CITY OF ALBUQUERQUE

March 13, 2019

**Re: Juan Tabo Hills Estates (Volterra)- DR Horton Homes
Erosion and Sediment Control Plan
Engineer's Stamp Date –no stamp- (M21E018_H)**

Based upon the information provided in your submittal received 3-11-19, the above referenced plan cannot be approved to be included in the SWPPP or for NOI documentation review for grading and Building Permit until the following comments are addressed:

BMP MAP LEGEND

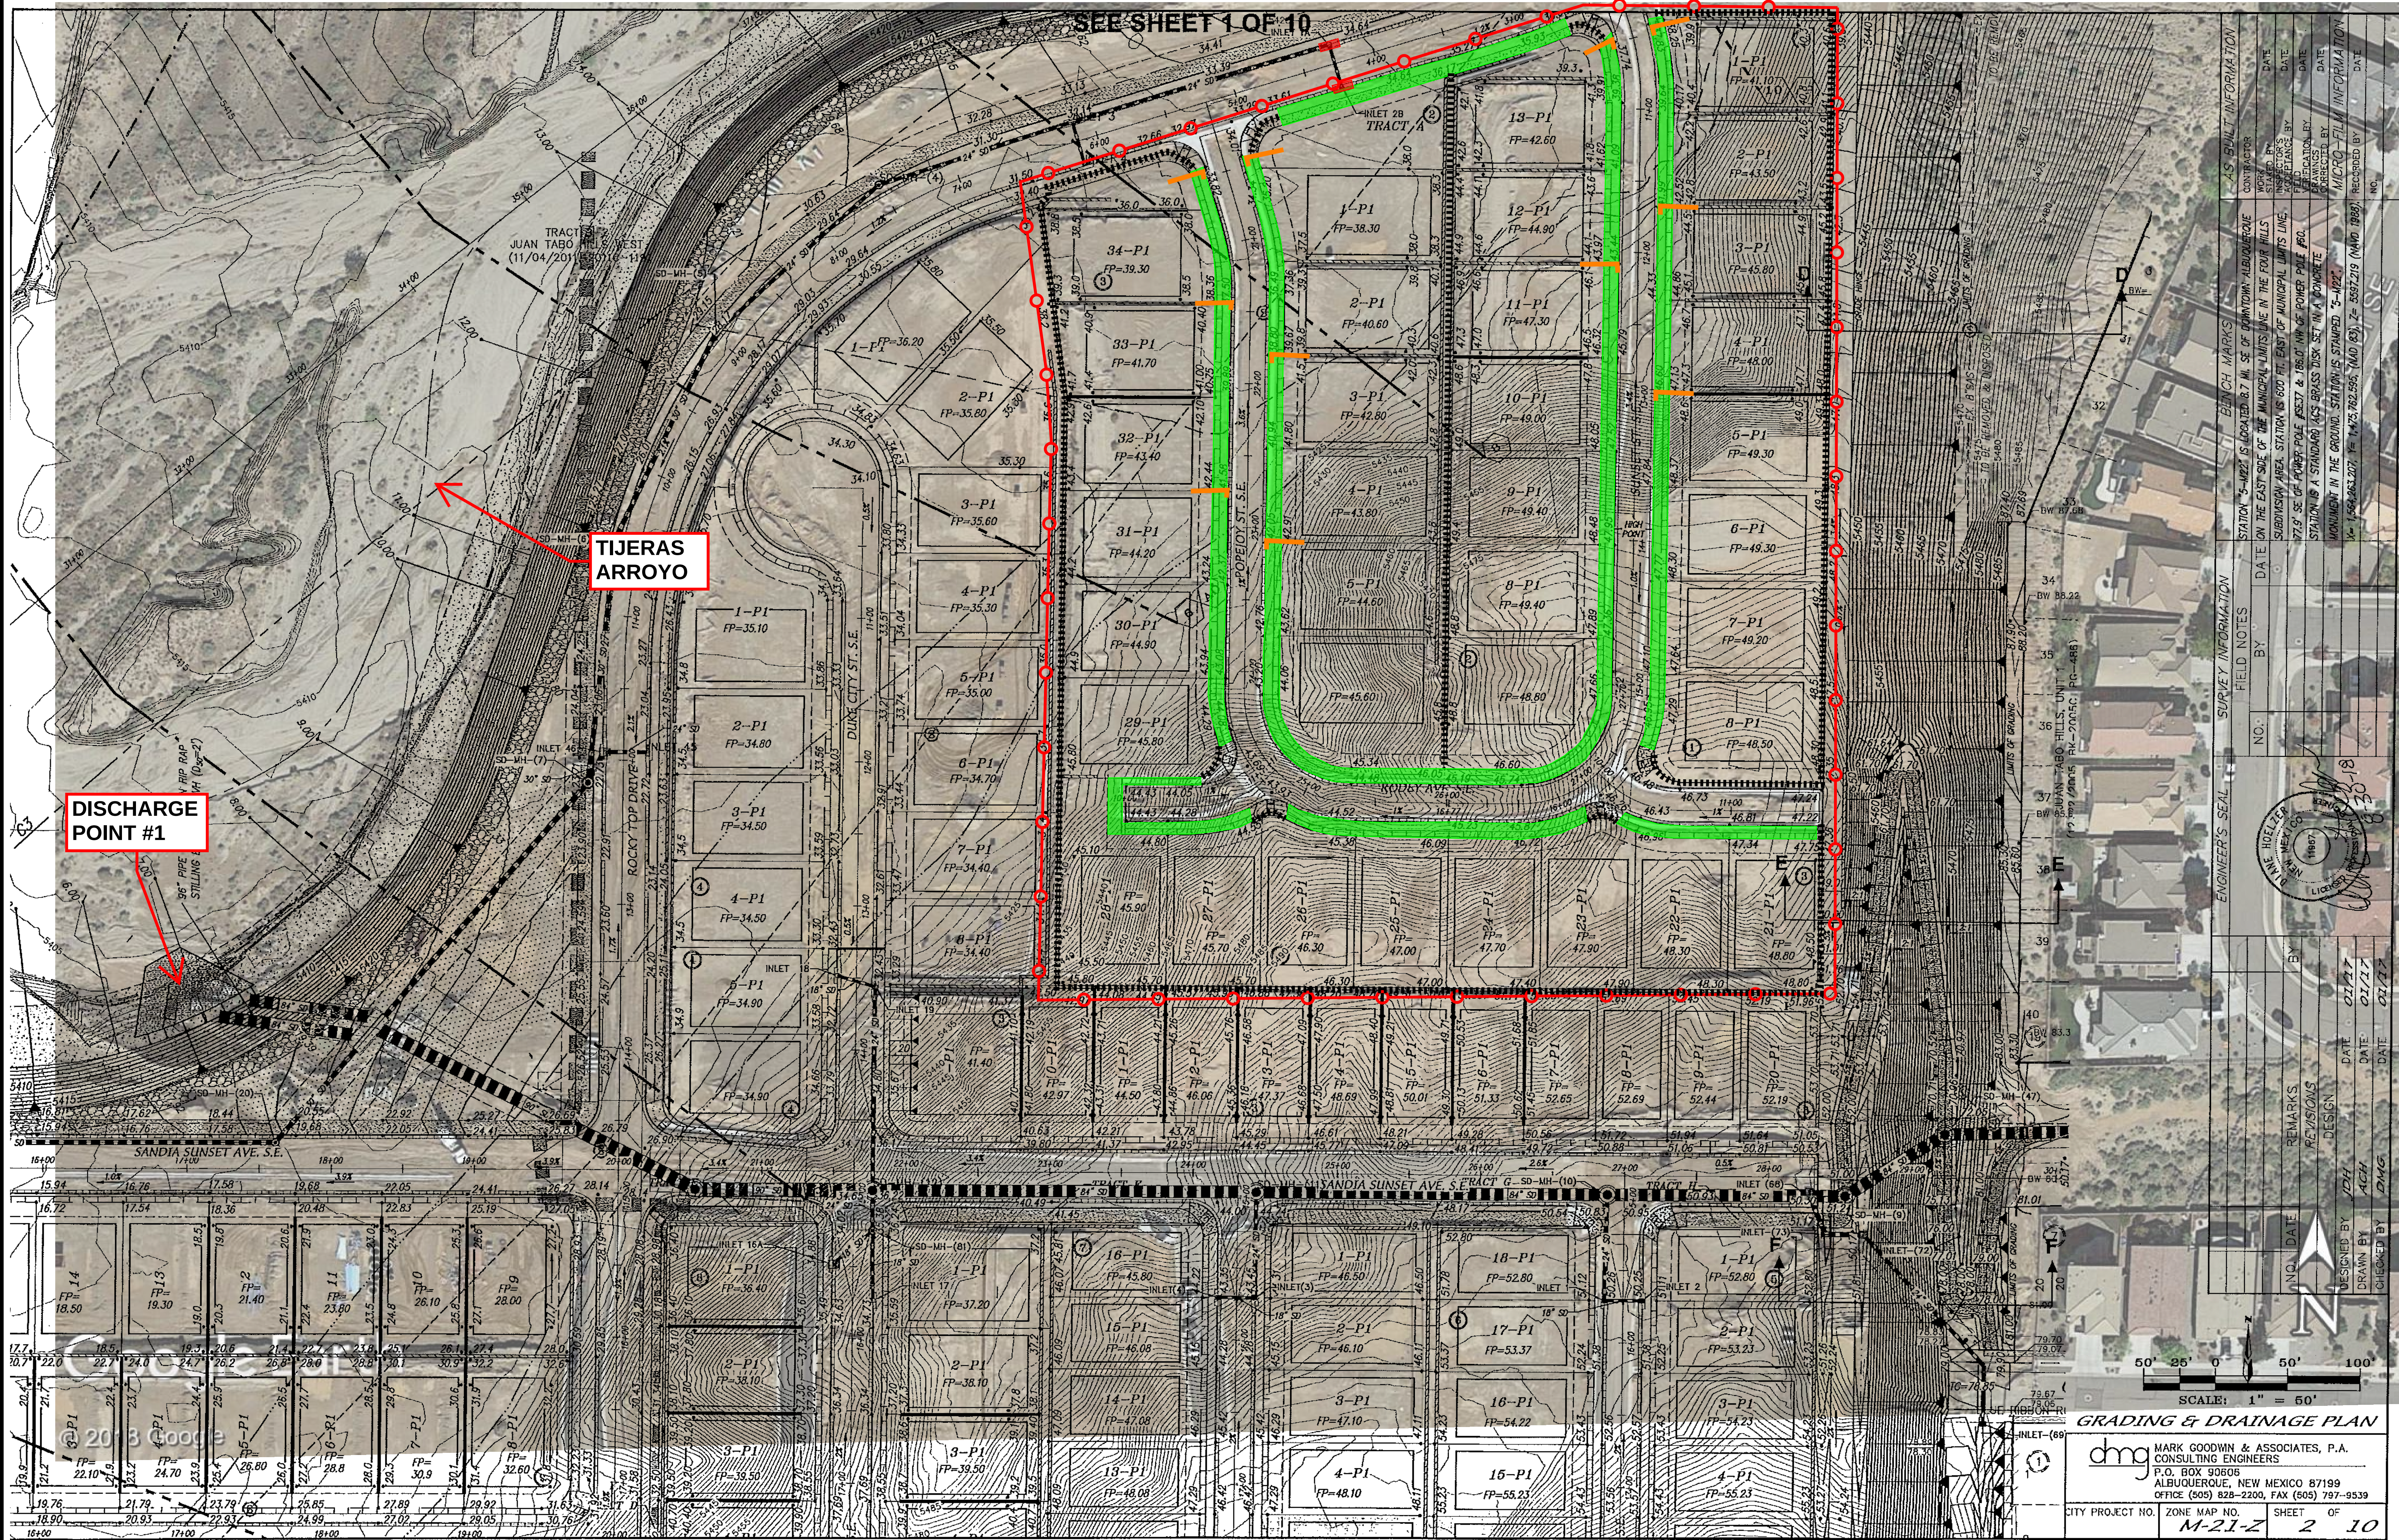
2. A filter sock, wattles or J-Hook silt fence at regular intervals is required in the cutback area on streets with a longitudinal slope steeper than 2.5% to help prevent erosion. Streets identified meeting this condition are: Fred Harvey-3.3%, Manzano Vista 2.66% and 3.2% and Sandia Sunset 2.6%. Slopes were obtained from the Work Order construction plans.
